**Our Ref: EP/105/11/
Your Ref:**

**The Town and Country Planning Act 1990 (as amended)
Town and Country Planning Development Management Procedure Order 2010 (as amended)**

**Conversion of house to 2 no. self contained 2 bed cottages
46 Old Worthing Road East Preston**

Project: Proposed conversion from 4 bed house to 2 2bed cottages; 46 Old Worthing Road, East Preston BN16 1DY	
Drawing: Block plan	
For: Mr. Lee	
Drawn: PKS	Date: August 2011
Scales: 1:500	No: 1160/01/06
To scale when printed on A3

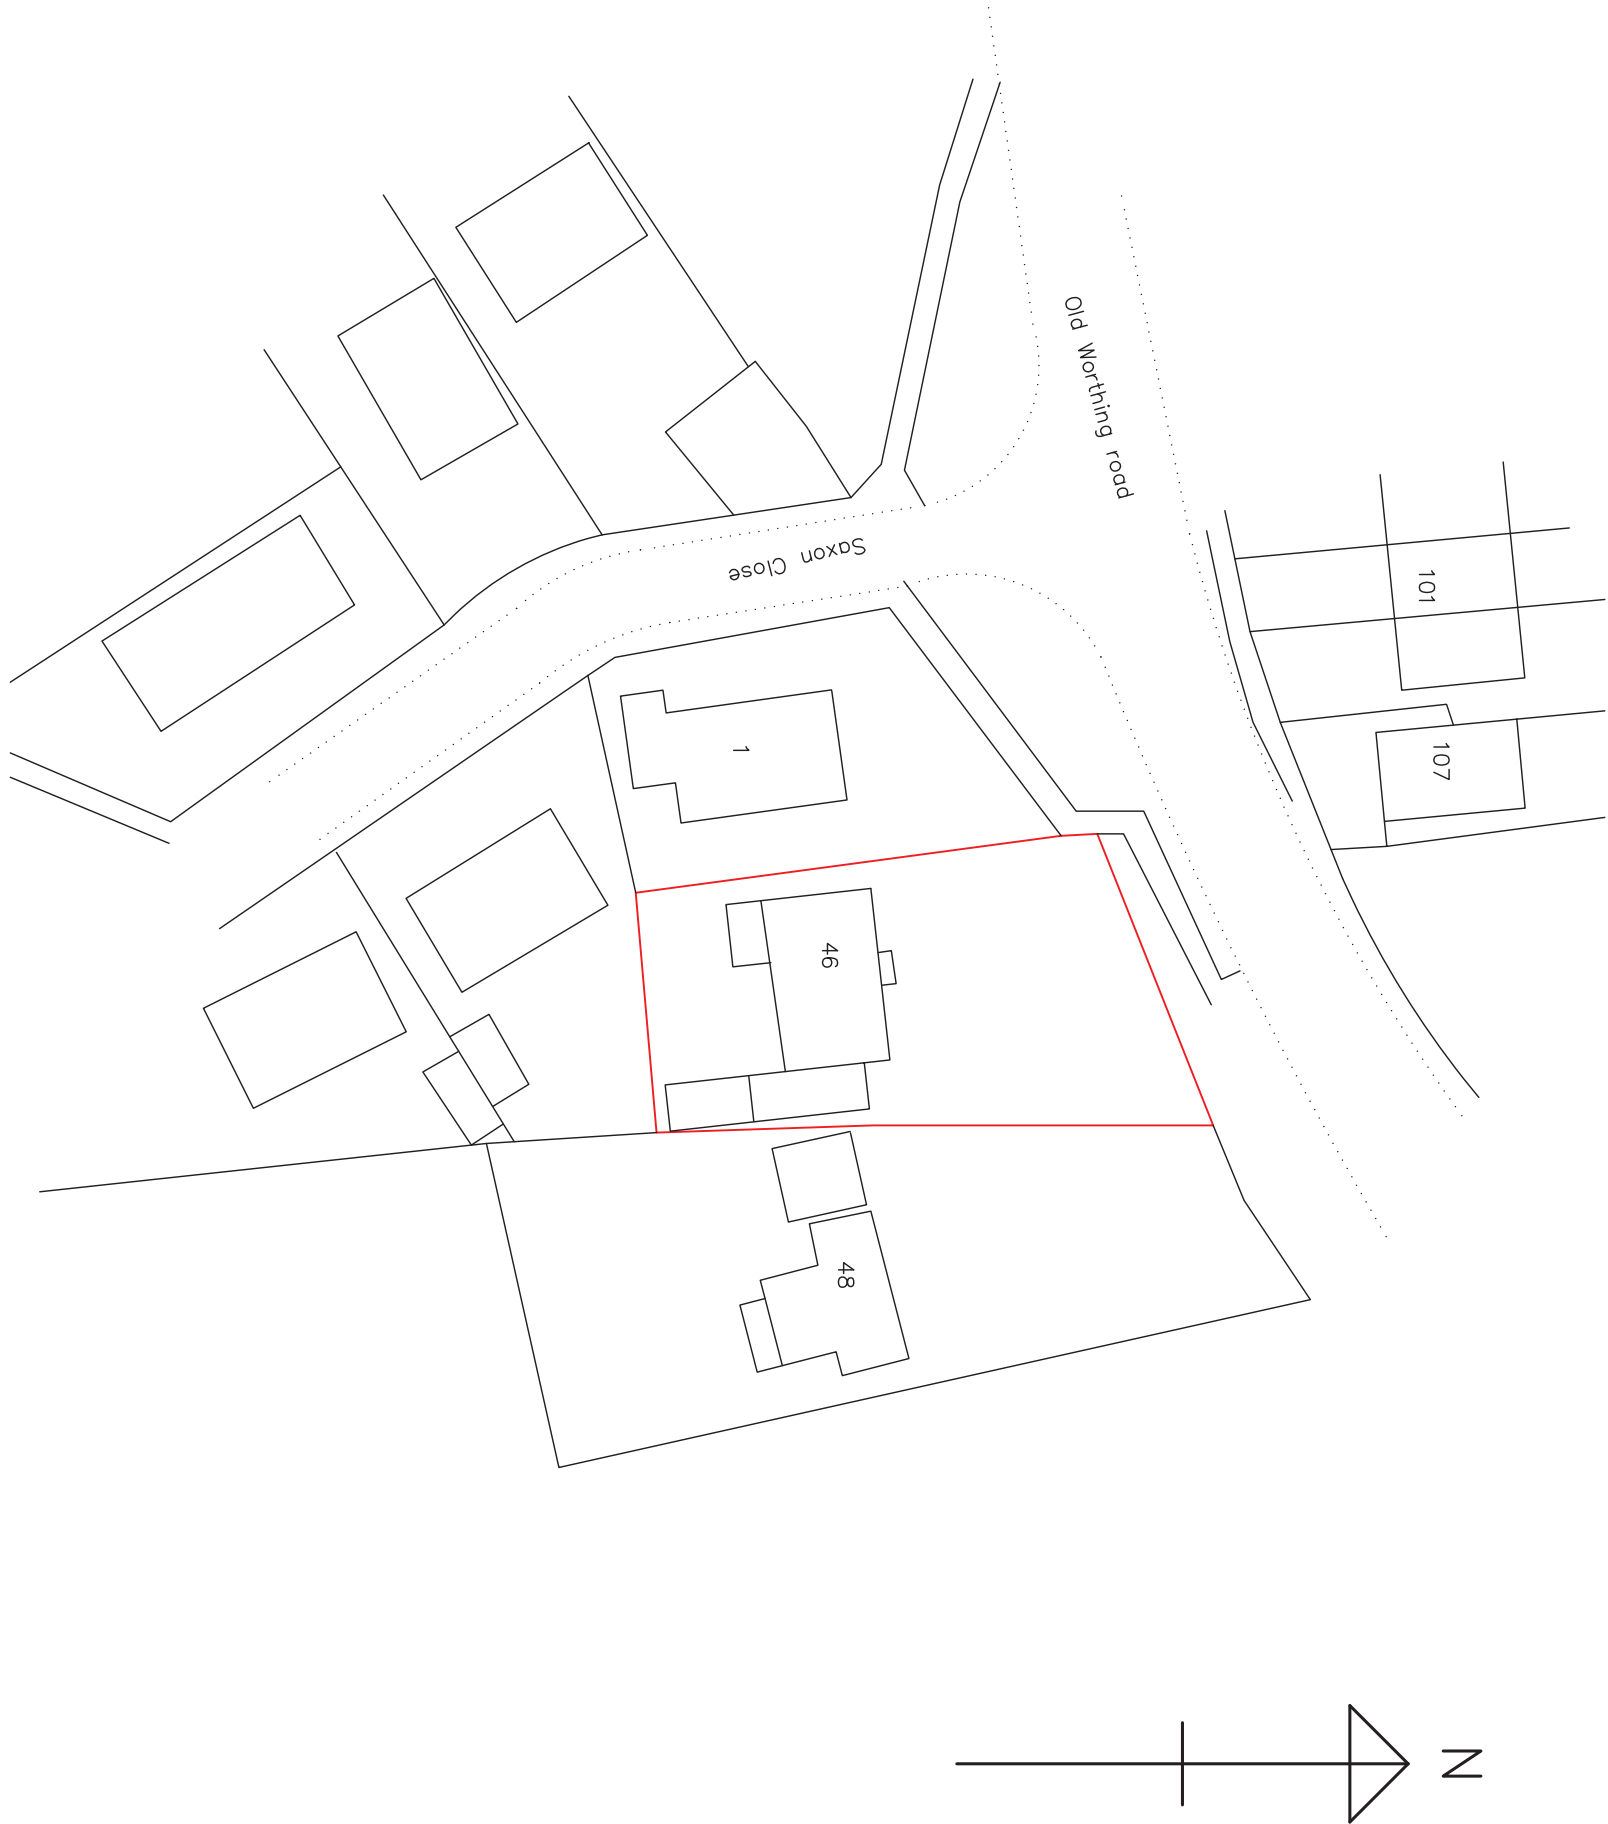
I require 1 electronic or 3 paper copies of a revised block and site plan. The footprint of the dwelling does not accord with the floor plans. Please amend.
